EN-010127 Mallard Pass Solar Farm

Deadline 10 - Closing Summary Statement

John Hughes ref ID 20036141

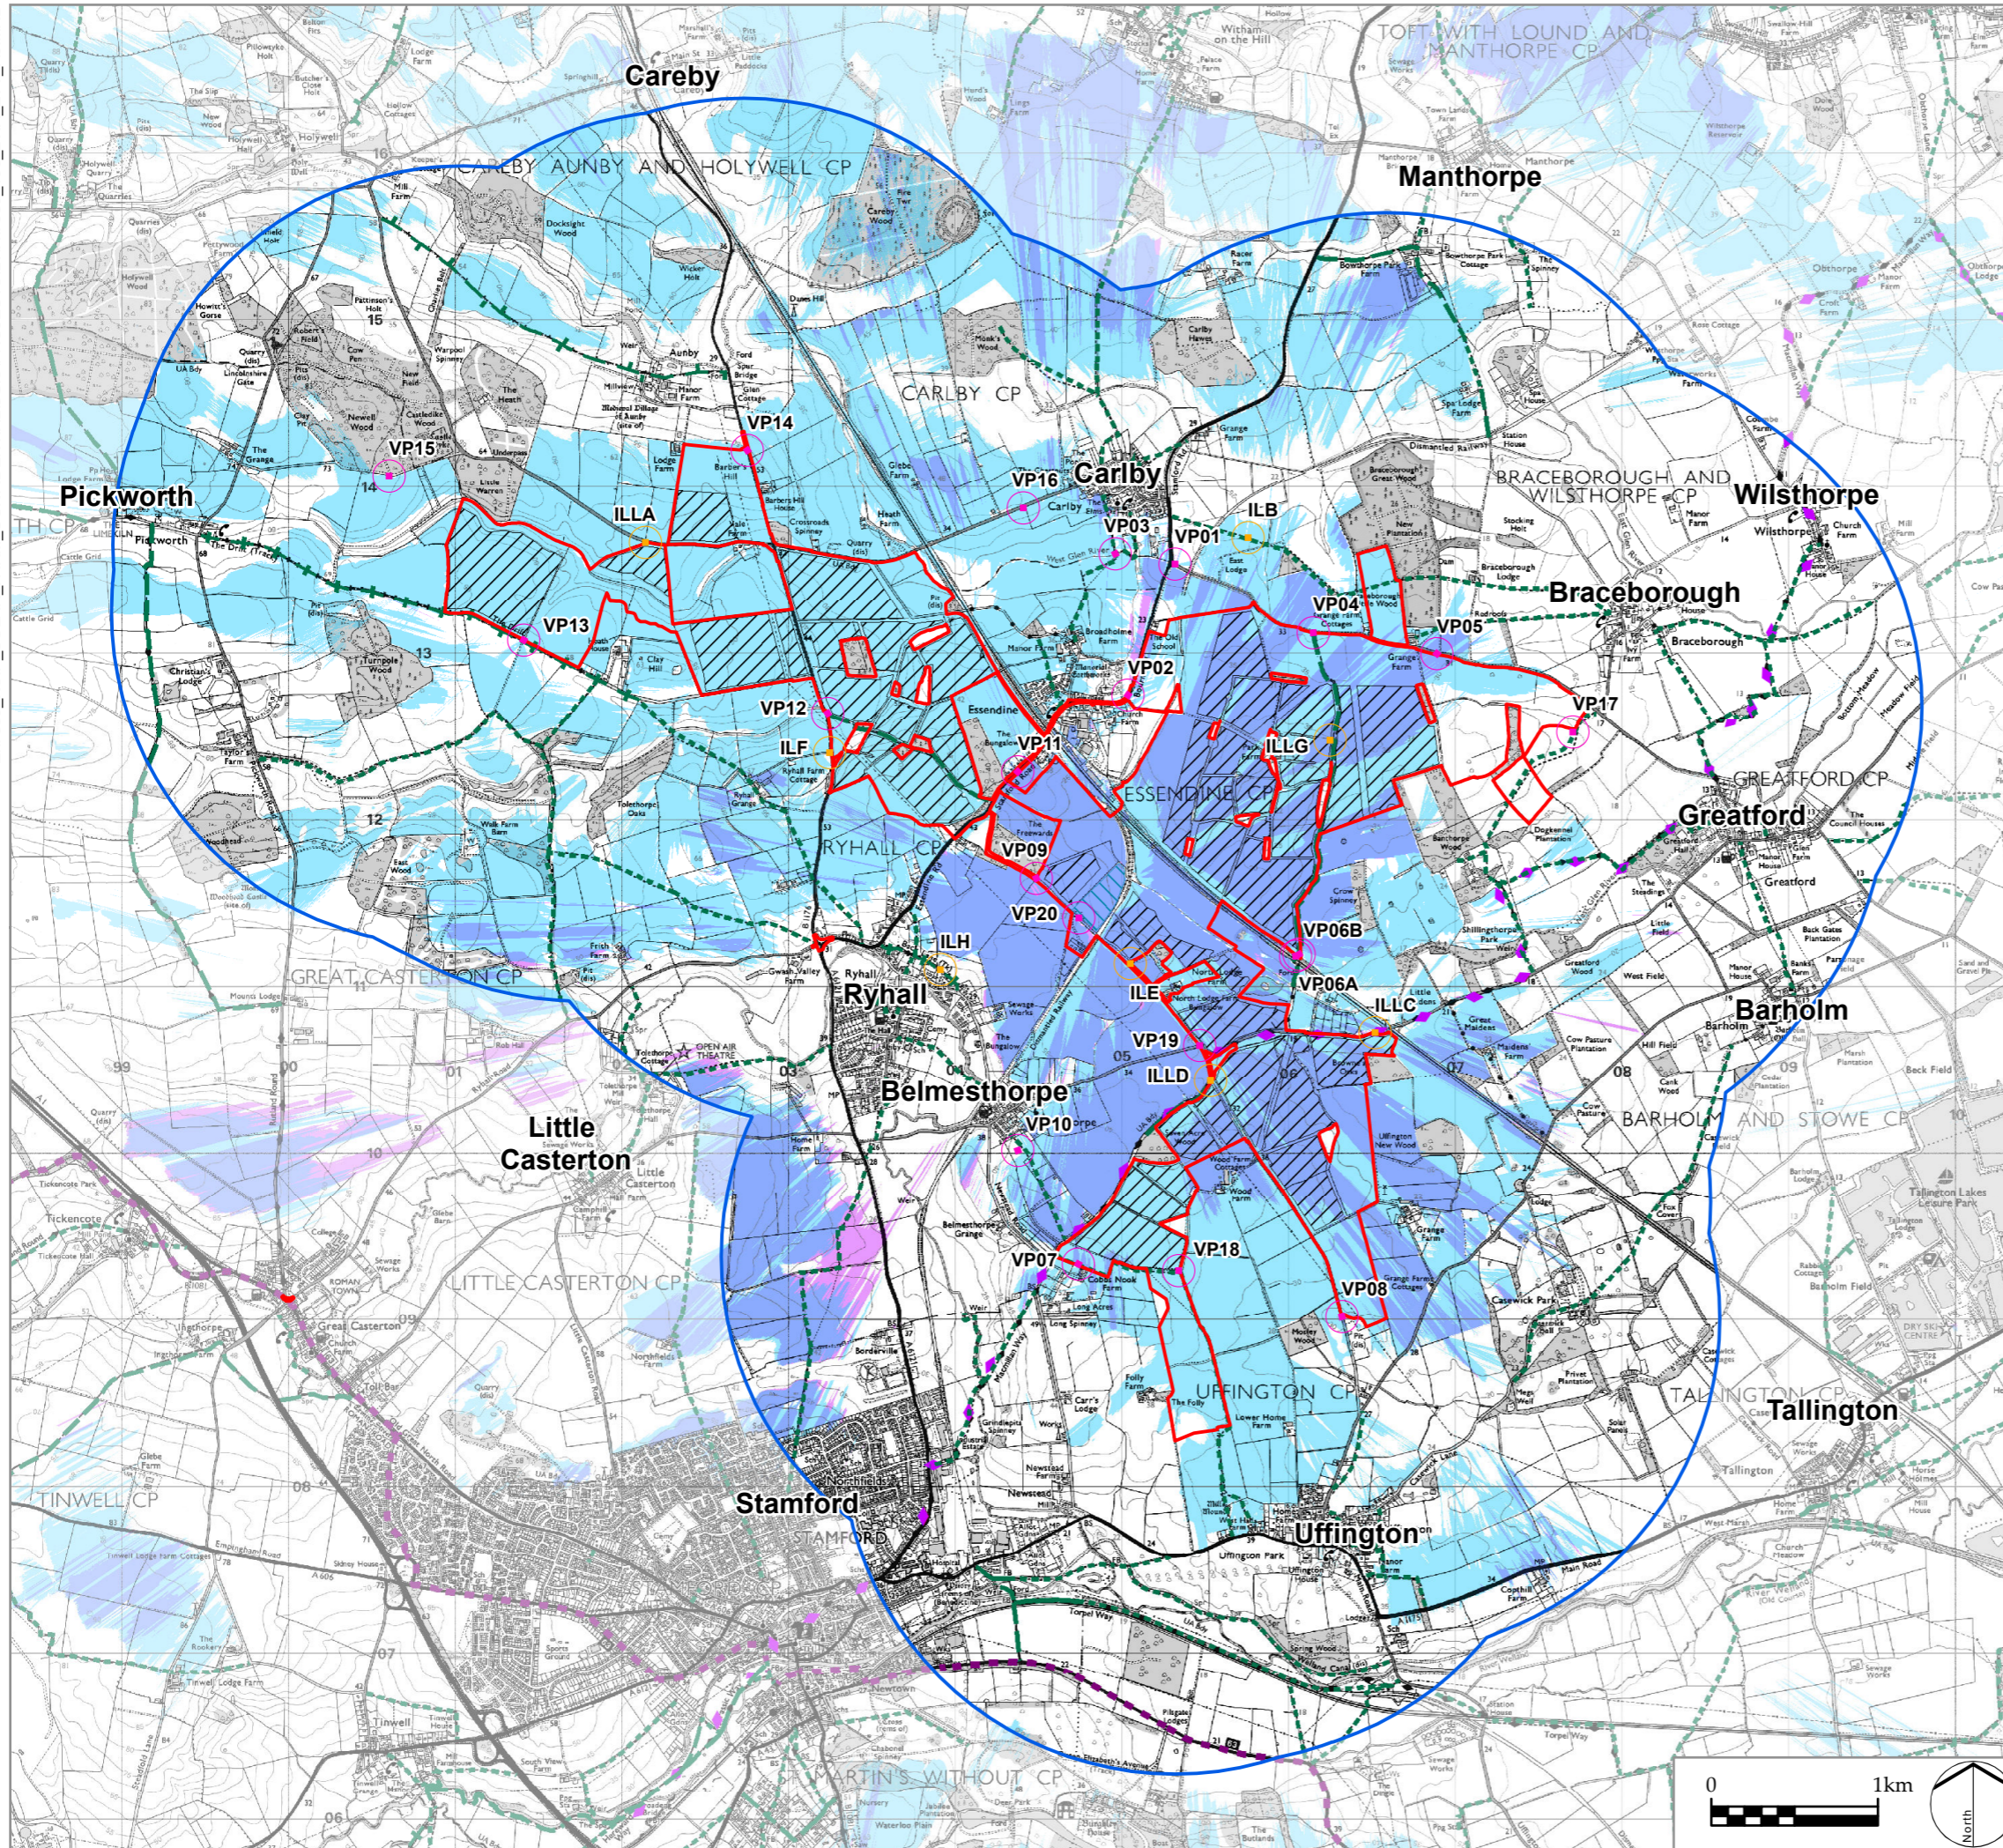
I submitted REP1-034 following Open Floor Hearing 1 on the 17th May 2022 in relation to the visual impact, REP2-172/173 asking for wire line drawings to reflect the true visual impact and stating nothing should be built in fields 26, 18 or 19, as well as who selected and approved the viewpoints being used for the representation as they are biased in the applicants favour.

At the very beginning of this project I asked if the dismantled railway line (vegetation on horizon) could be used as the visual boundary for those properties west of the ECML and the adamant answer from MPSF was No! I've asked if the PV Arrays can be removed from field 18 and they responded with a lie saying they had mitigated the issue by removing them from field 26.
